Meeting Minutes – SSDA Consultation Meeting with Griffith City Council No. 1

Date and Time	18 December 2020, 11:00 am – 12:30pm
Venue	Zoom Meeting

PROJECT: Griffith Base Hospital
RE: HI SDRP SESSION 01 – 10.03.21 (Third Review)

**Figure 3: Sewer Connection Locations**

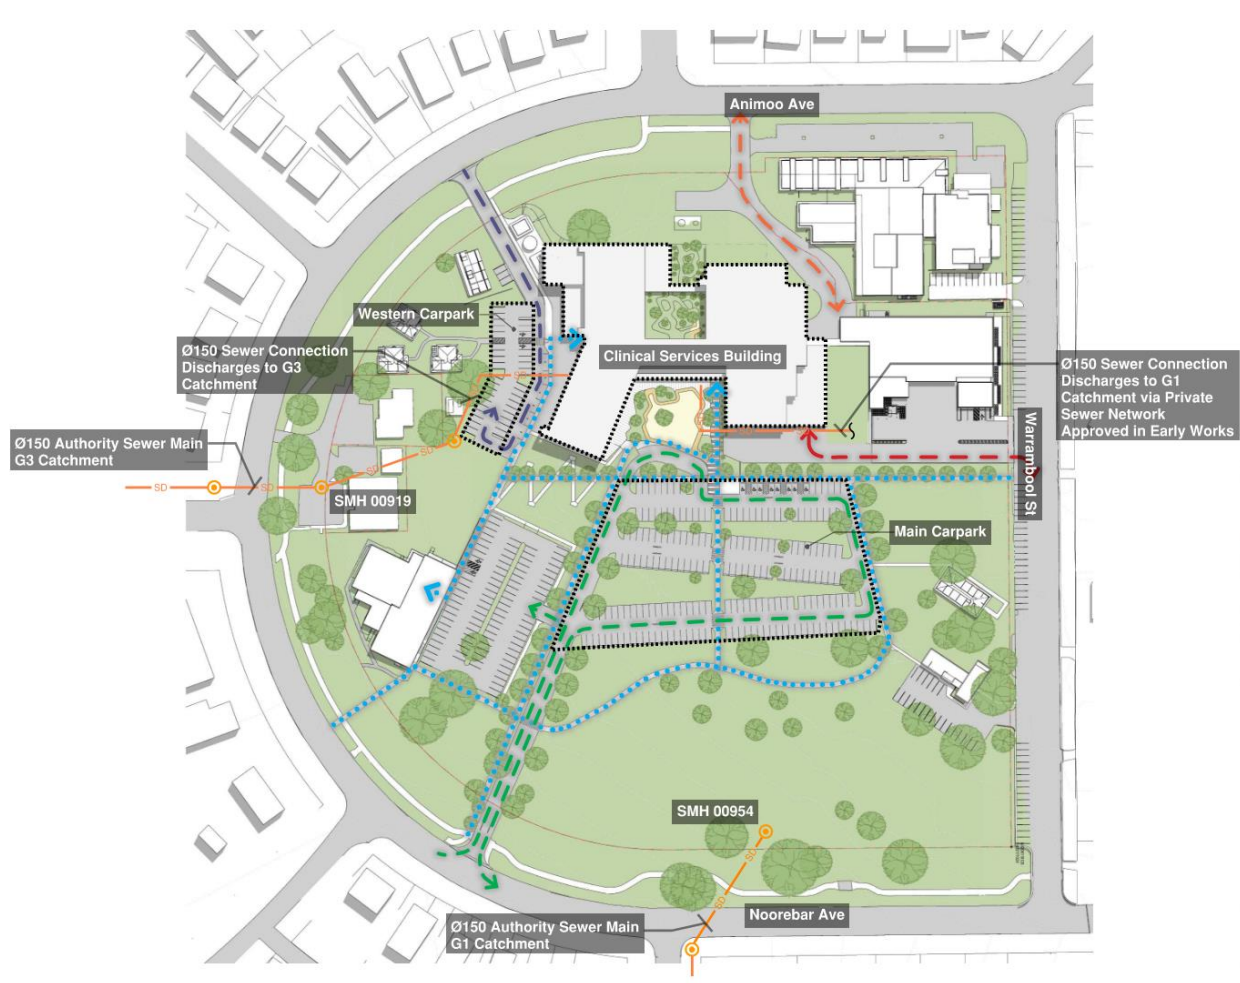
2.5.5	<p>GG asked if there is sewer storage onsite given catchment G3 currently has limited capacity. AK responded that there is no sewer storage onsite as there is a minimal increase in sewer discharge to G3 catchment. AK also mentioned that only the Lower Ground Level sewer discharge will be directed to G3 catchment. All the other levels of the CSB will be distributed to G1.</p> <p>AK noted that Stantec are the primary hydraulic engineering contact for the Griffith City Council.</p> <p>ATM to provide Stantec's sewer discharge calculations to GCC to show that a majority of sewer discharge is going to G3 catchment.</p> <p>ATM to schedule meeting with Griffith City Council, Hutchinson Builders, A Murray and Sons, and Stantec week commencing 11 January 2021 to close out sewer connection queries for the Griffith Base Hospital redevelopment early works project, which is currently in progress onsite.</p>	<p>ATM</p> <p>ATM</p>	23/12/20

Griffith City Council reiterated their preference for discharge to be directed to G1 catchment instead of G3 (which is currently shown on drawings)

Figure 4: Stormwater Drainage System

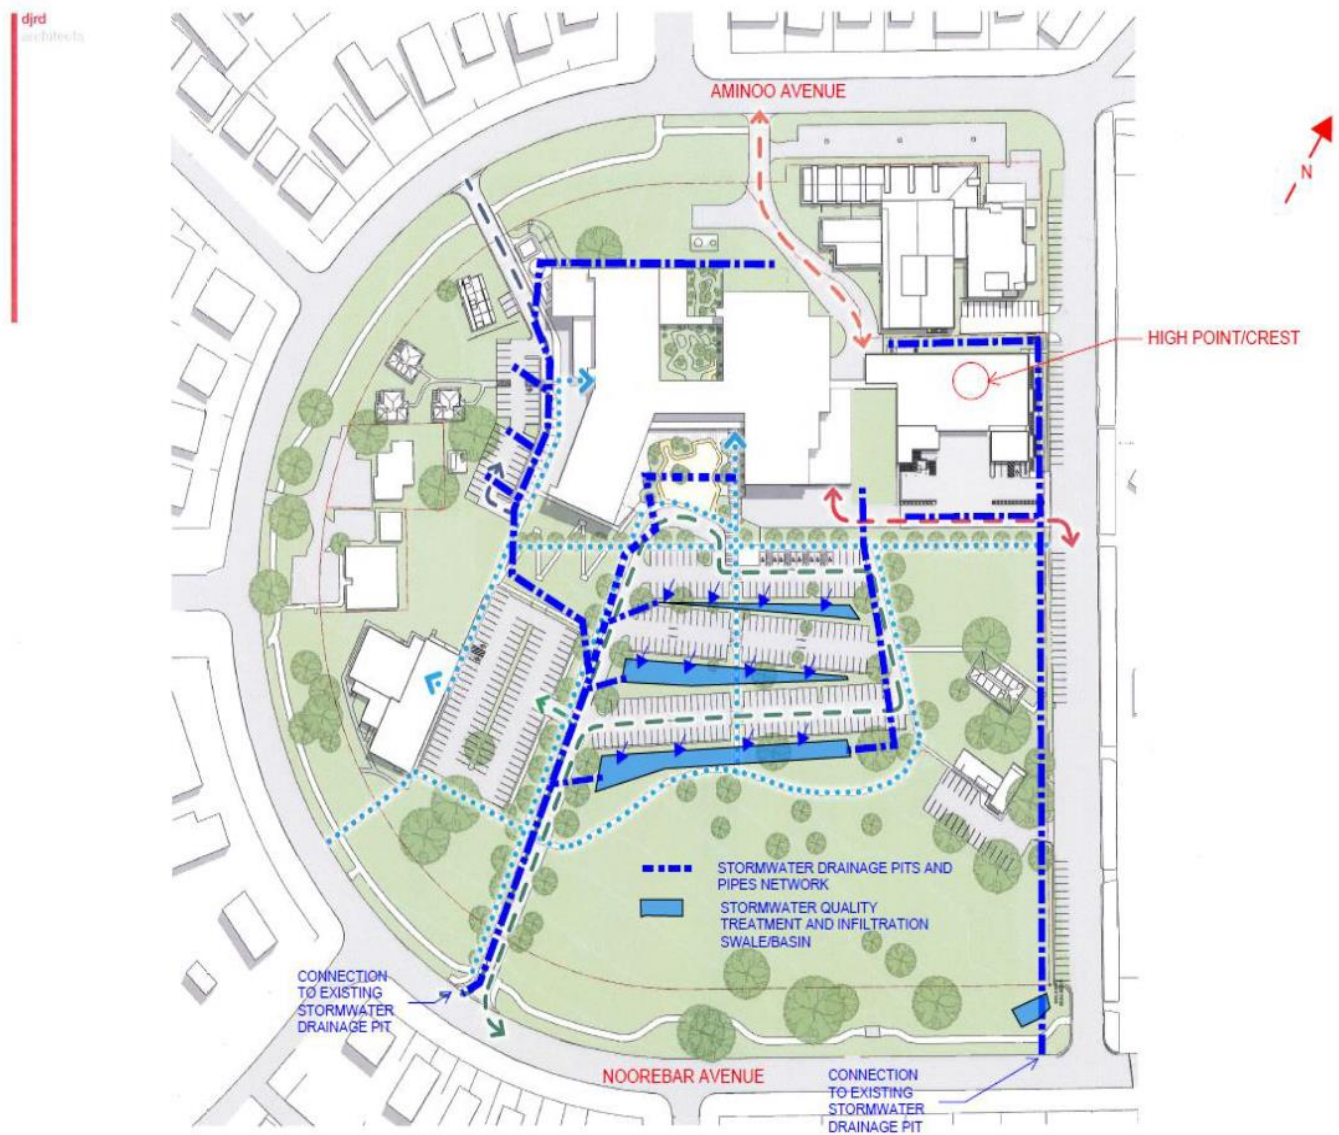
Health Infrastructure and **Hutchinson Builders** to review location and capacity of surface spreader/infiltration bed A2 against council requirement for overflow to be contained within the site boundary

Bonacci and **Hutchinson Builders** to update documents to use a 150mm dia pipe between pit A3-A1 and enlarge surface spreader/infiltration bed as required
